Planning Application Ref: A/4/21/PL

Location: Quiet Waters, Roundstone Lane, Angmering, BN16 4AX

Description of works: Variation of condition 1 imposed under A/38/20/PL relating to approved plans

TITLE Detailed Landscape Proposals

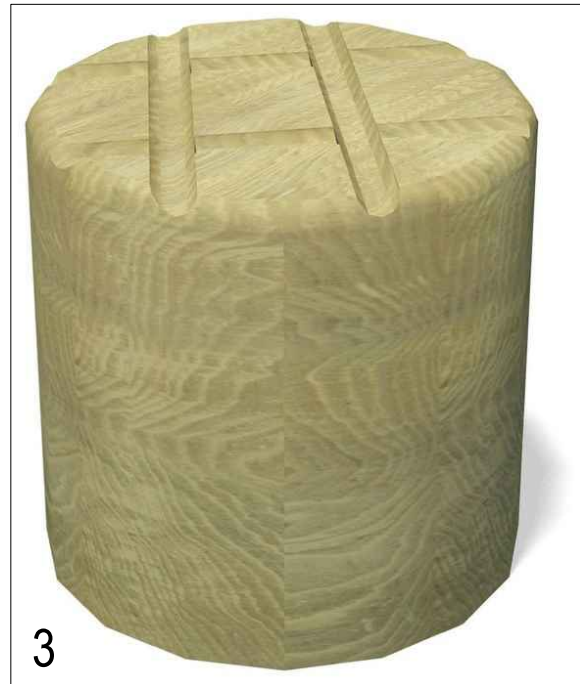
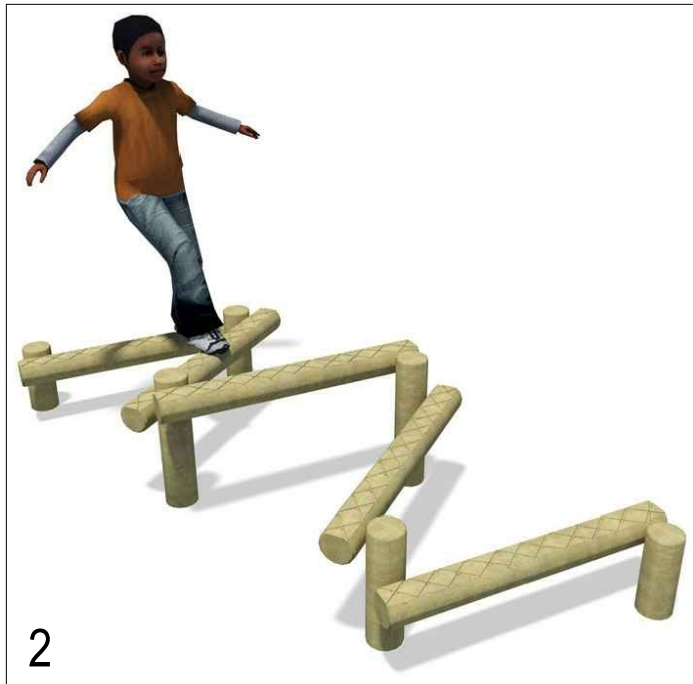
- The replacement Norway maple has been illustrated on the plan drawing 'Detailed Landscape Proposals', 2903/1, Rev J. I find the location SW of T54 to be unsatisfactory as it: will be in direct competition with other large tree types, relatively obscured and outside of the area from which it could enjoy Statutory Protection under the existing Order – TPO/A/1/17.

- The majority of post-development tree work operations as proposed are acceptable, with the notable exception being inappropriate siting of replacement for T53.

- I recommend the above scheme for **APPROVAL**, subject to the following condition being applied:
- Once the Norway maple tree (T53) has been felled (and either grubbed or ground out) then a replacement tree is to be planted in the same place or nearby and to within 10metres due East of London plane (T54).

This is to be of Standard Nursery Stock proportions (10-12cm girth & 2m to 3m overall height) supported on a 'short stake' system with appropriate securing ties and pads.

It is to be planted within 12 months of the removal of the Norway maple tree.

Norway maple *Acer platanoides*
